Town & Country Planning Act 1990 (as amended)
Town & Country Planning (Development Management Procedure) (England) Order 2015

Application for Planning Permission for Works or Extension to a Dwelling

Development: Proposed single storey extension, and new first floor dormer.
Location: 52 Glynde Crescent Felpham PO22 8HT

GROUND FLOOR PLAN 1:50

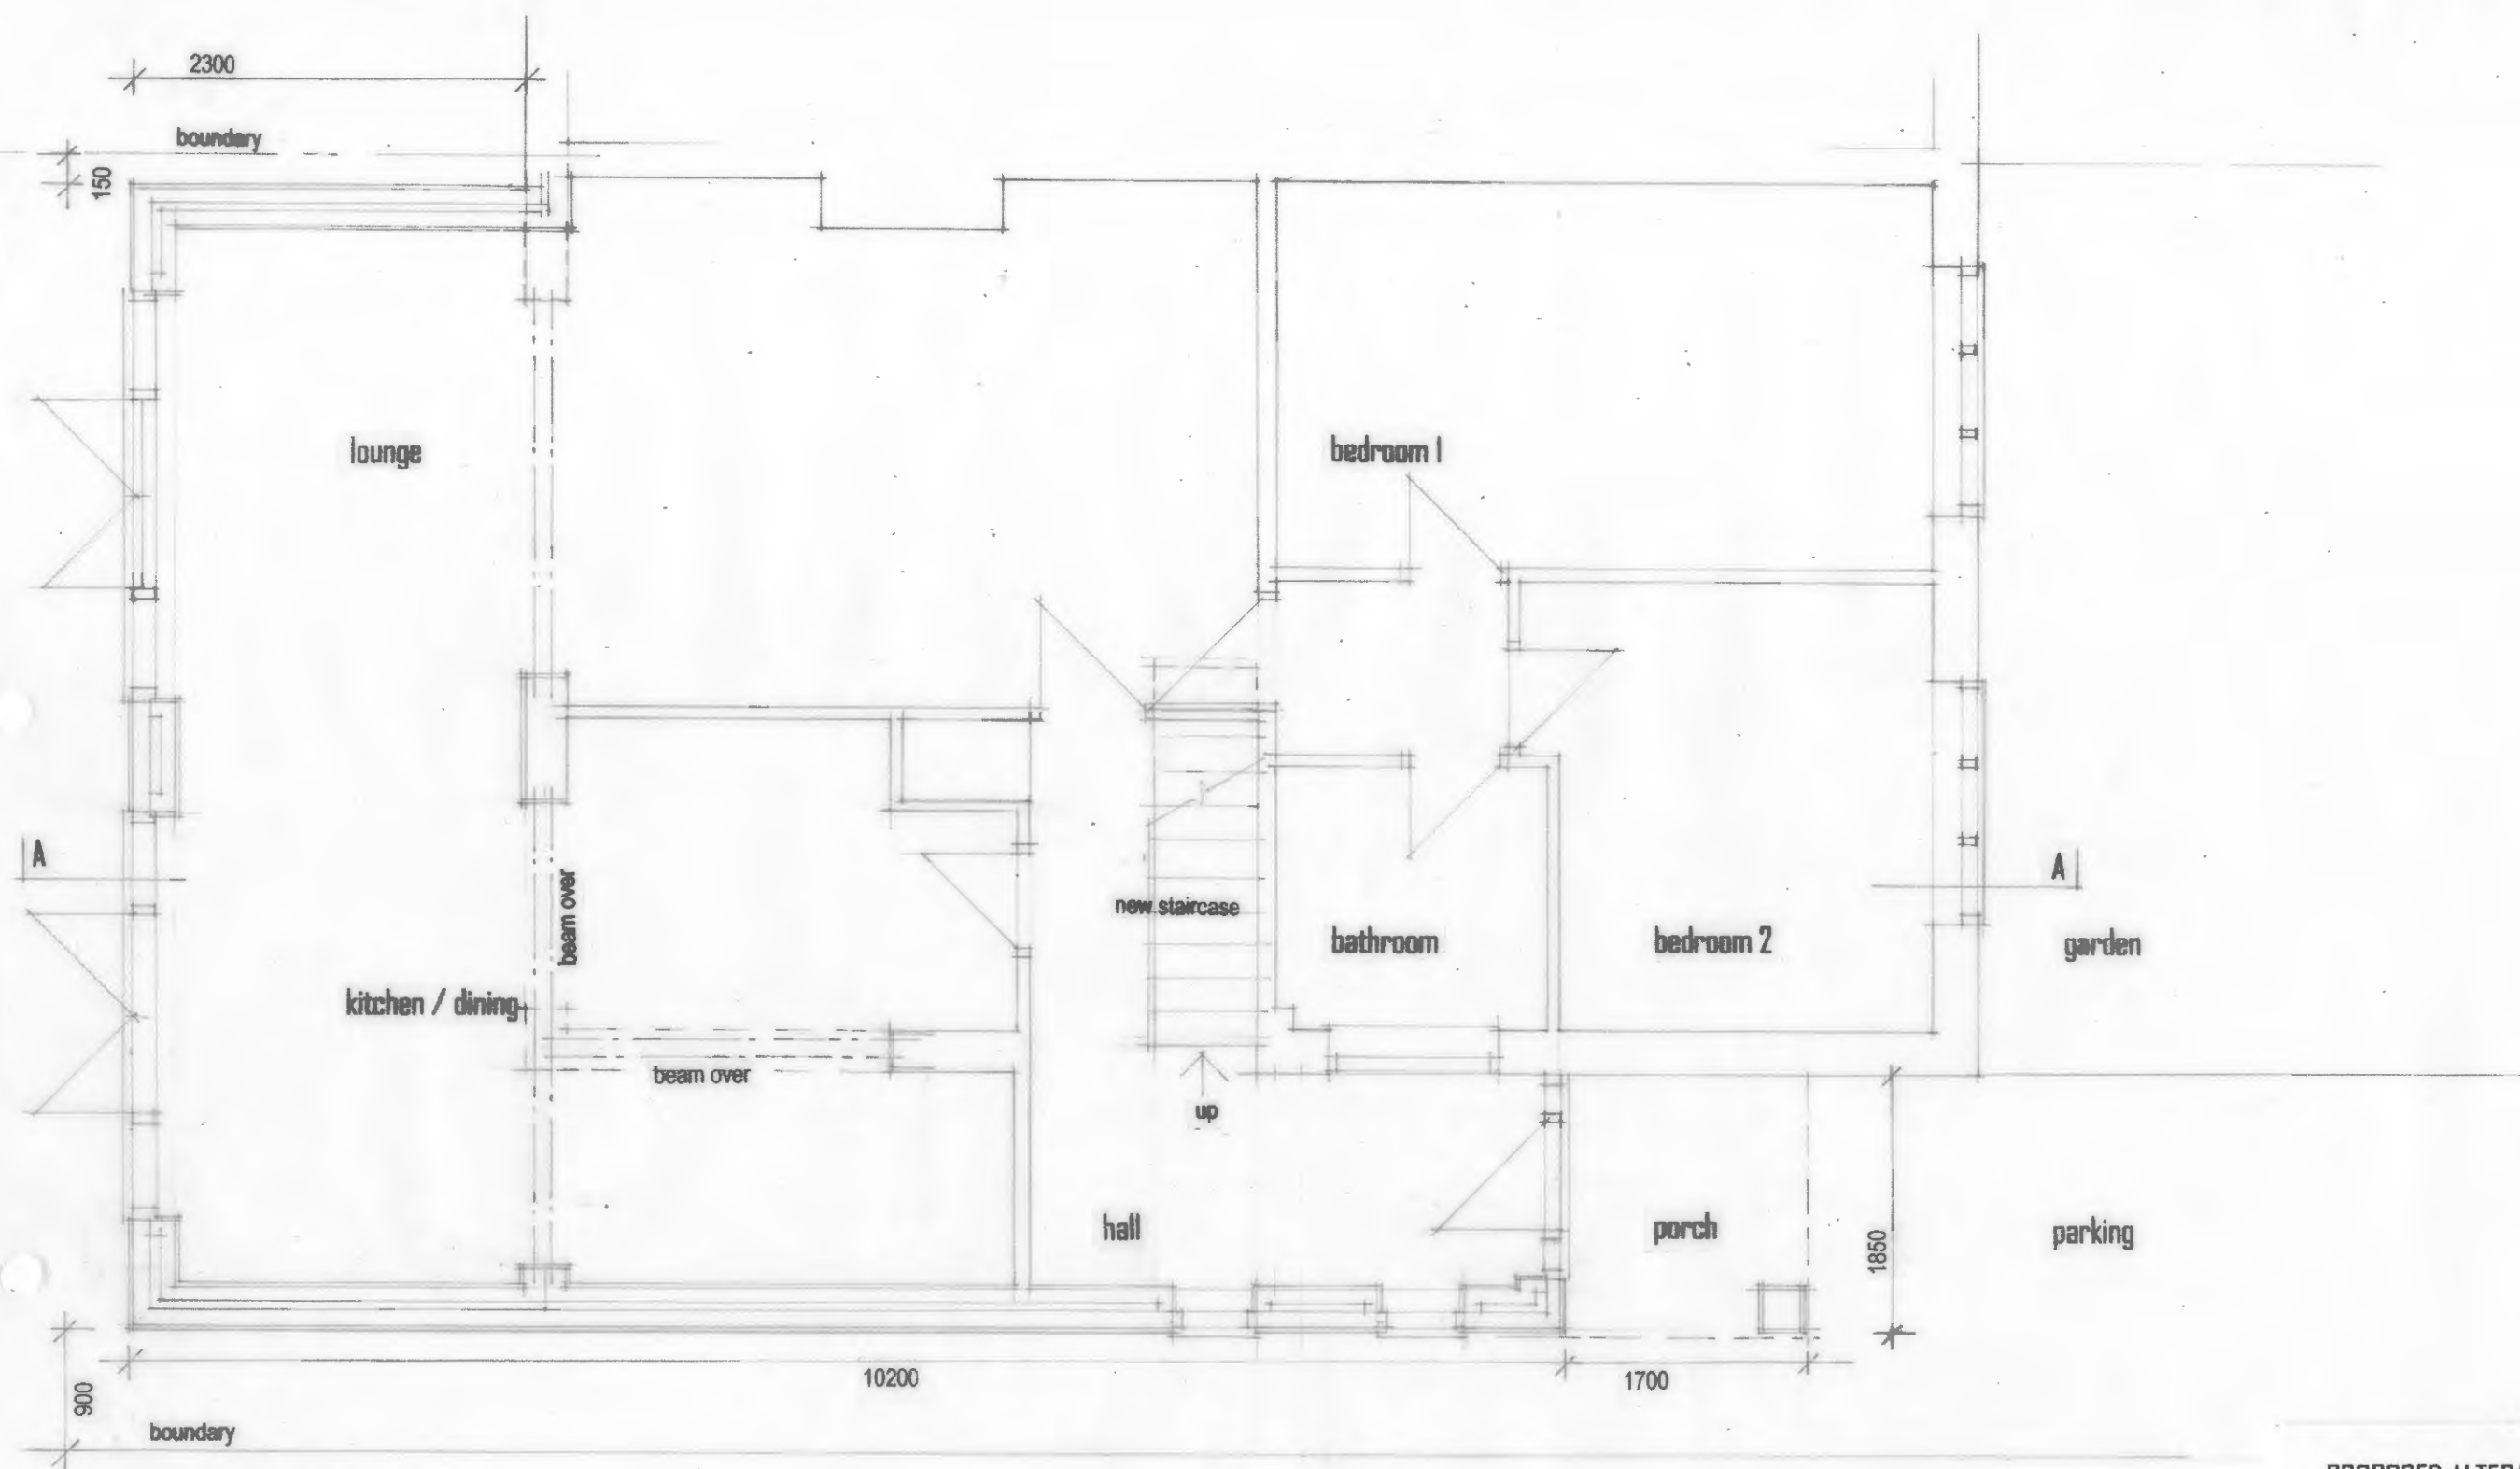
Scale: The proposed floor plans are not to scale. Please amend

SOUTH EAST ELEVATION 1:100

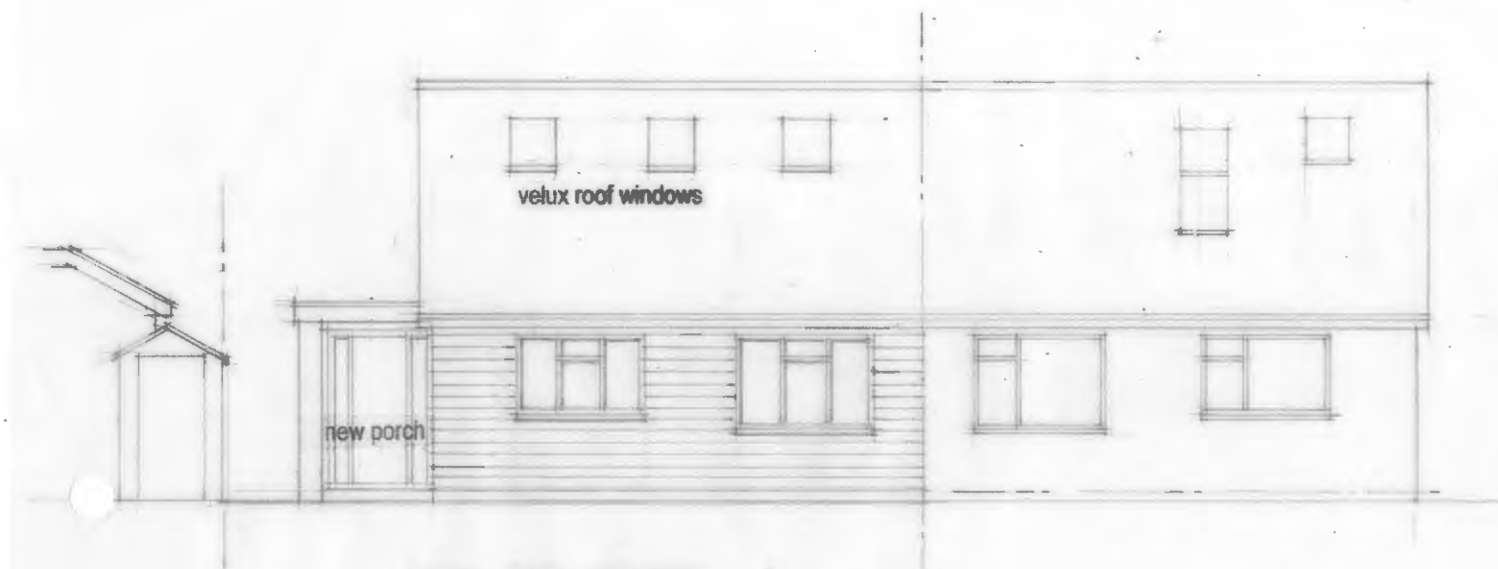
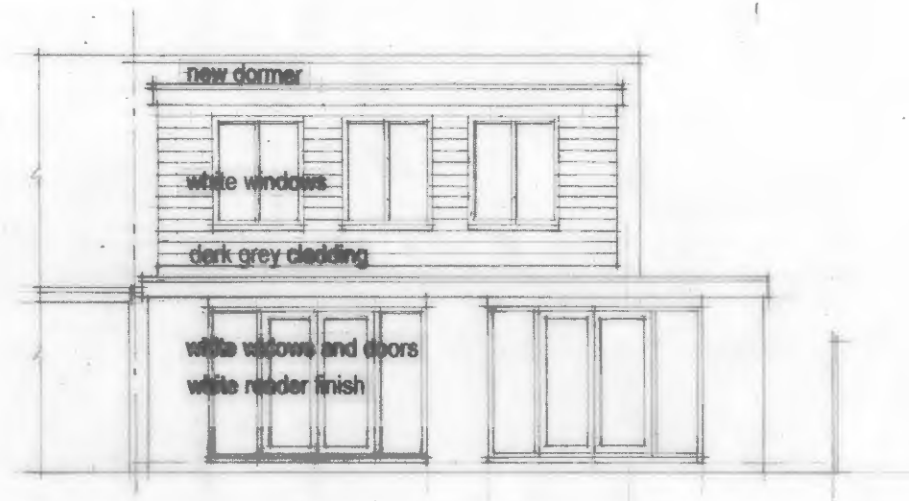
Other Side Elevation: Please provide the other side elevation for this application
